**State Significant Development – SSD-5093
M2 site, North Ryde Station Urban Activation Precinct**

As such, Sydney Trains has undertaken a review of this development proposal and provides the following comments:

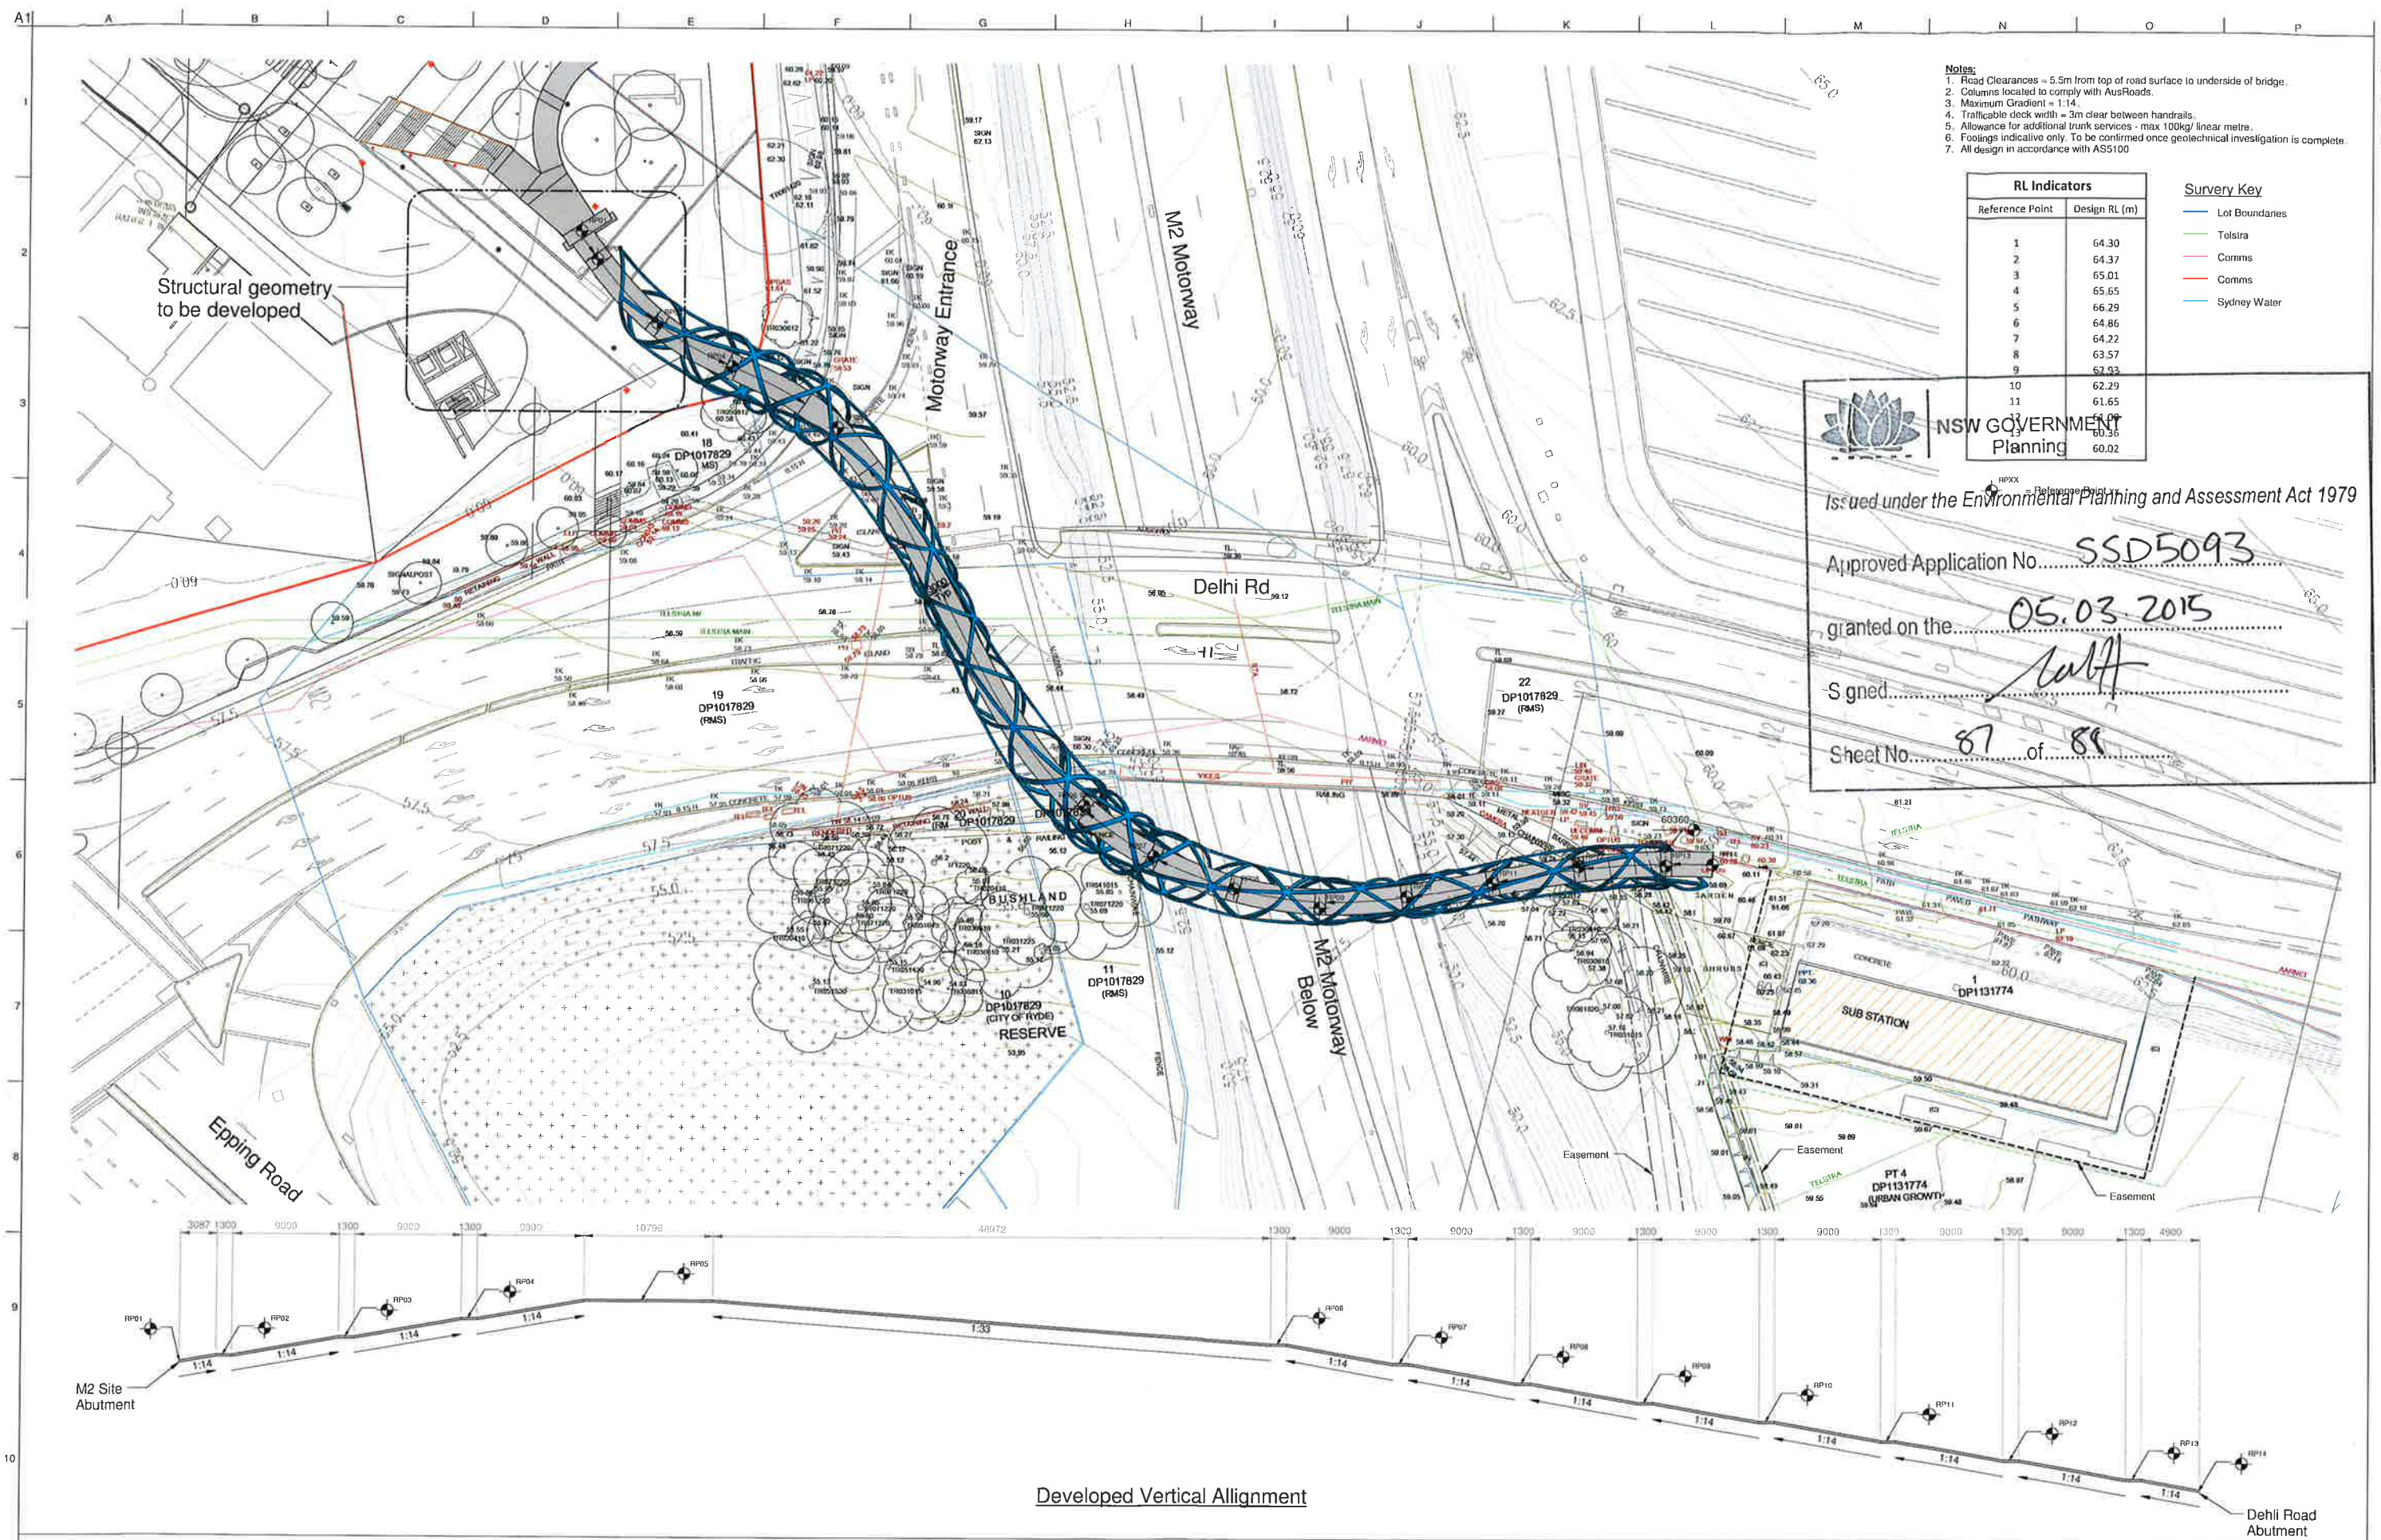
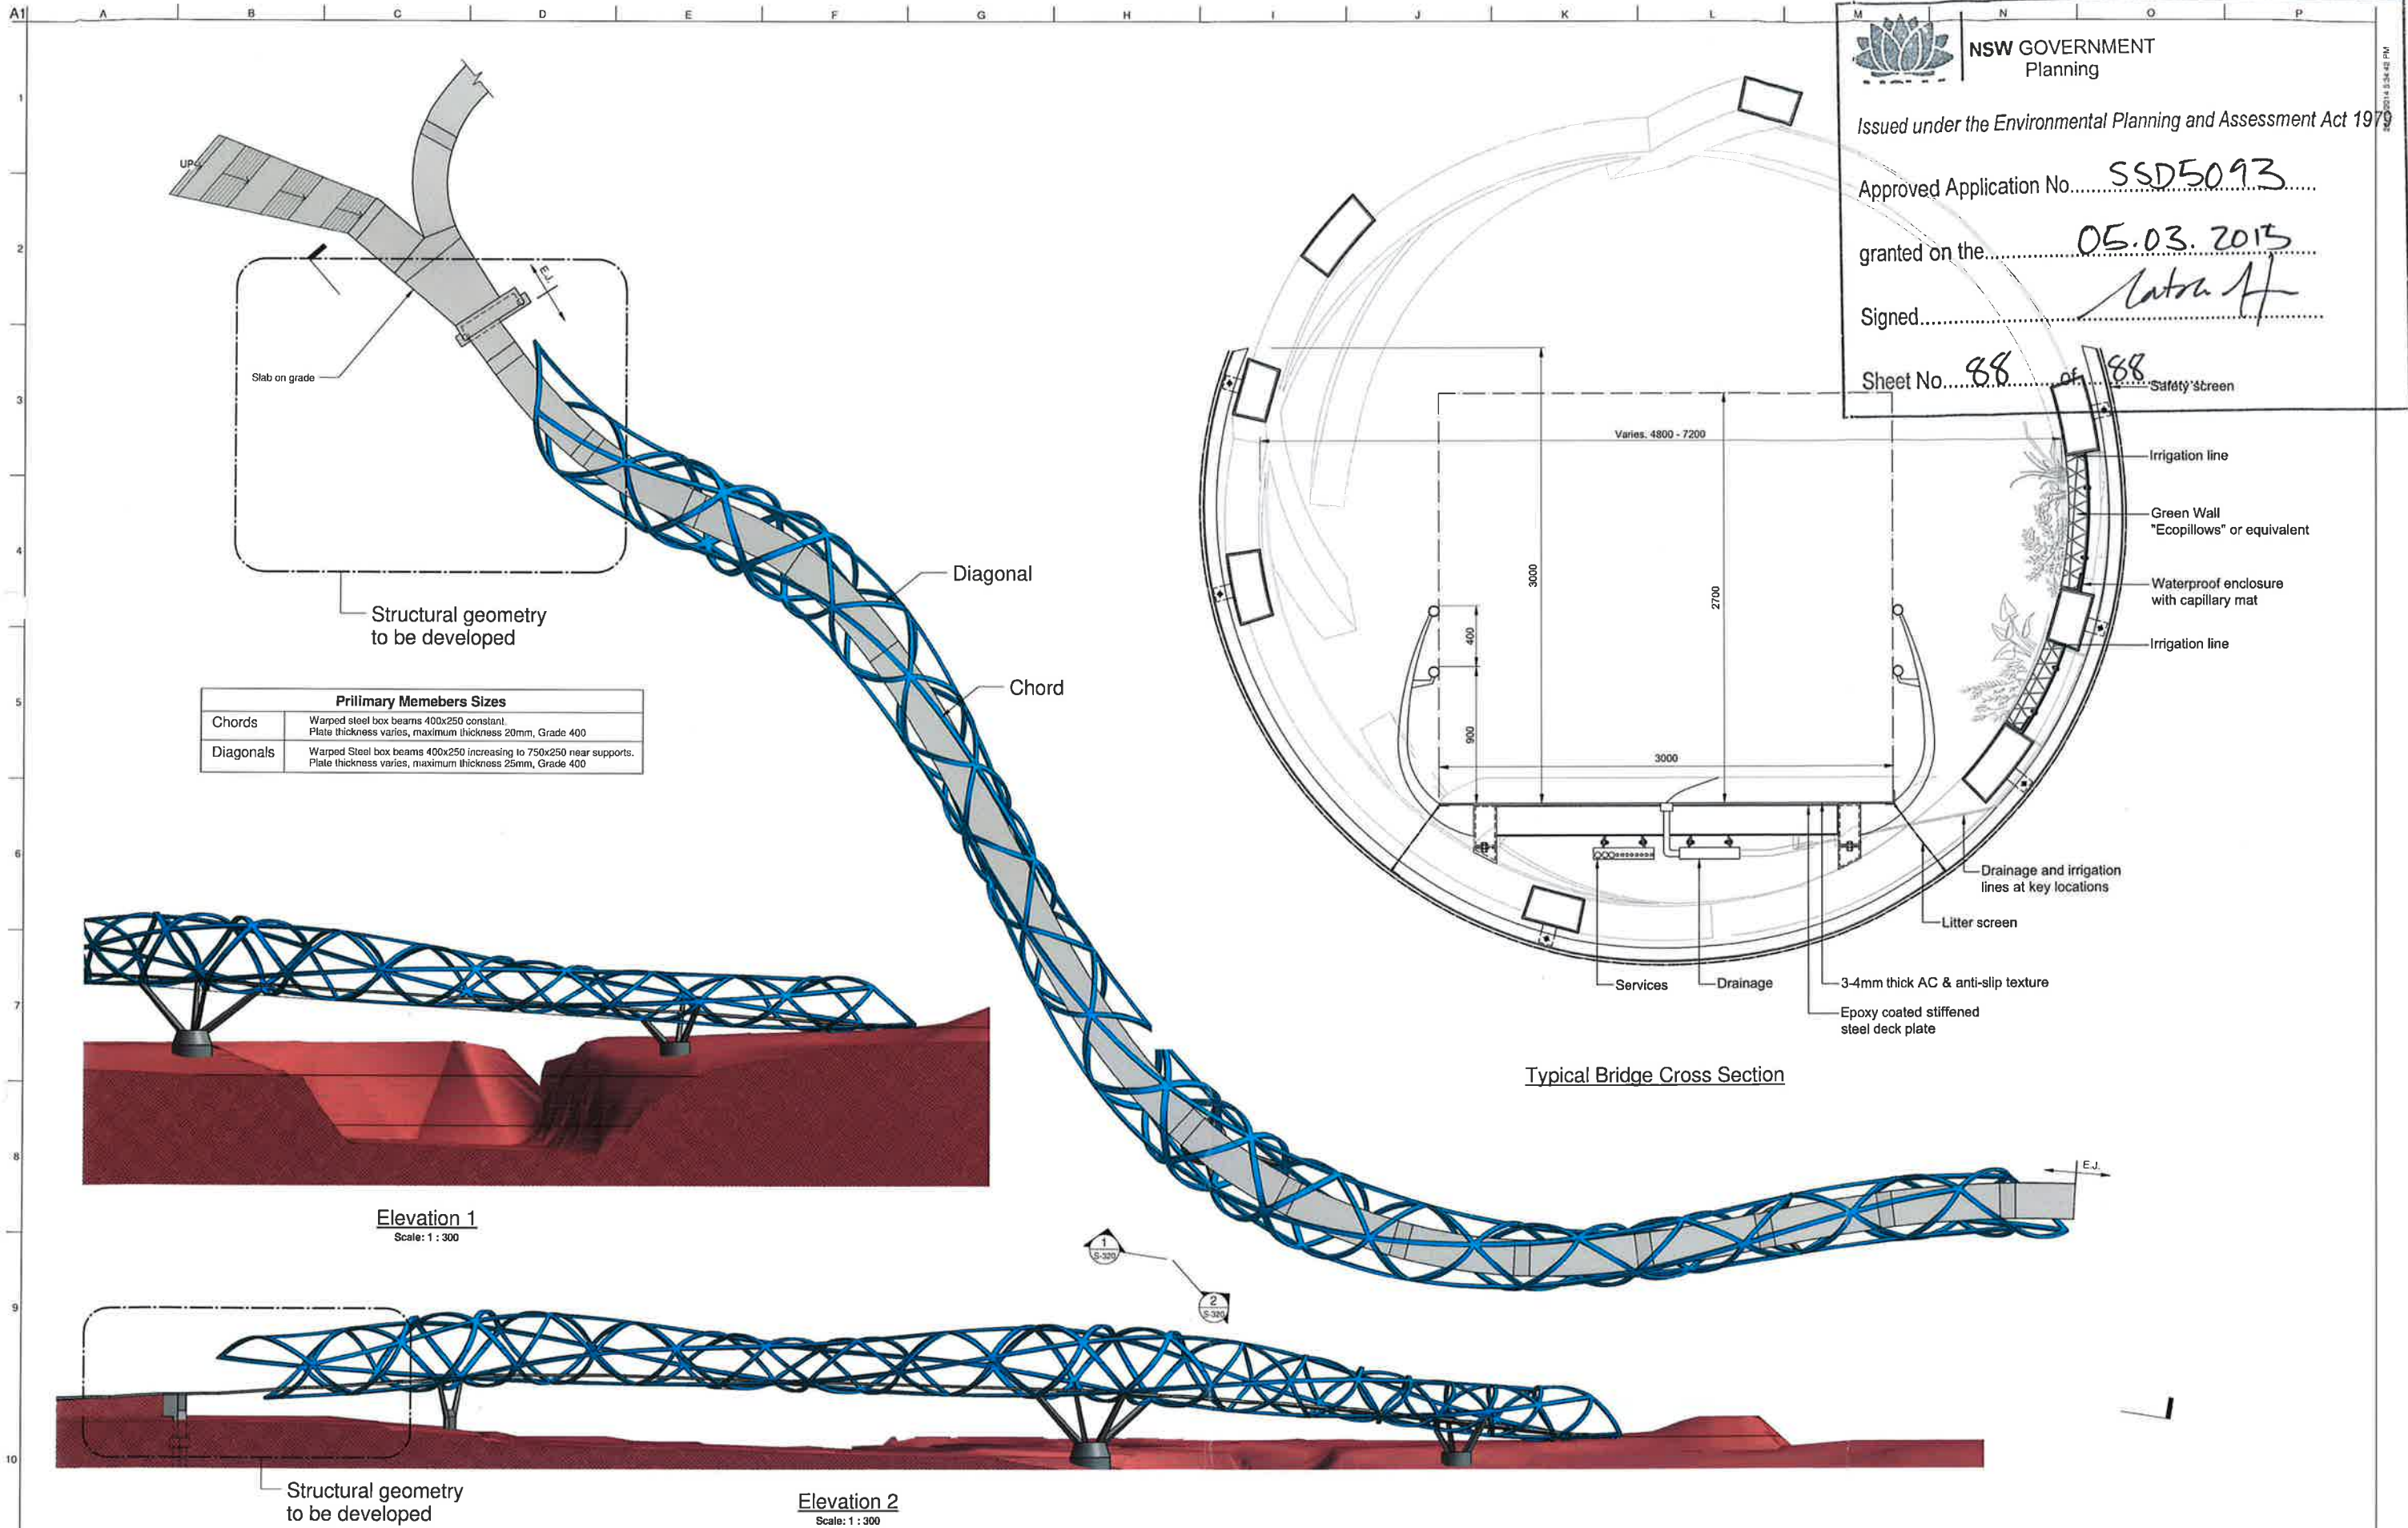
- *The shared pedestrian and cycle bridge is to be modified to ensure that no part of the bridge is located within the Sydney Trains easement surrounding the substation located on Lot 1 DP 1131774.*

- *No bridge columns/piers are to be installed above or within 25m of the rail corridor until the following documentation has been submitted to, and endorsed in writing by, Sydney Trains:*

1. *Final Geotechnical and Structural report/drawings that meet Sydney Trains requirements. The Geotechnical Report must be based on actual borehole testing conducting on the site closest to the drainage system.*

2. *Final Construction methodology with construction details pertaining to structural support during excavation.*
 3. *Final cross sectional drawings showing ground surface, drainage infrastructure, sub soil profile, proposed basement excavation and structural design of sub ground support adjacent to the drainage system. All measurements are to be verified by a Registered Surveyor.*

4. *Detailed Survey Plan showing the relationship of the proposed developed with respect to the Sydney Trains drainage system.*
 5. *If required by Sydney Trains, an FE analysis which assesses the different stages of loading-unloading of the site and its effect on the rock mass surrounding the rail corridor.*
